Comments in respect to the outstanding points;

Formpave permable block paving private driveway construction

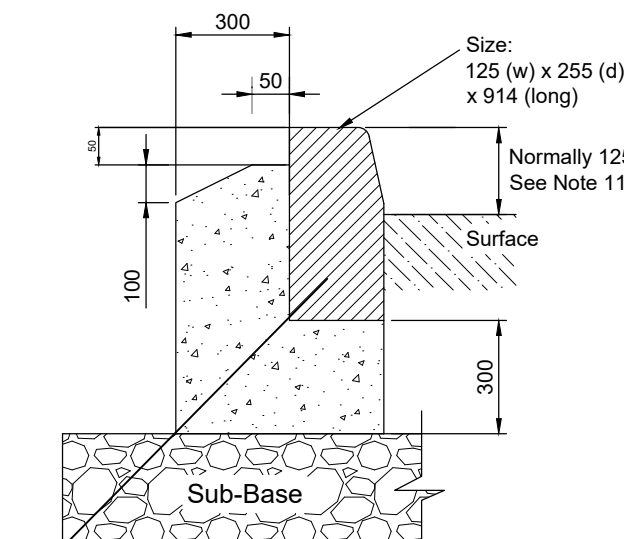
11. I note that the driveway construction has now changed to blockwork. Please make it very clear that the upper layer of inbitex geotextile is porous and the ibitex geomembrane is impermeable – this is for the benefit of the contractor. – Note added onto drainage layout and detail updated to make it clearer.
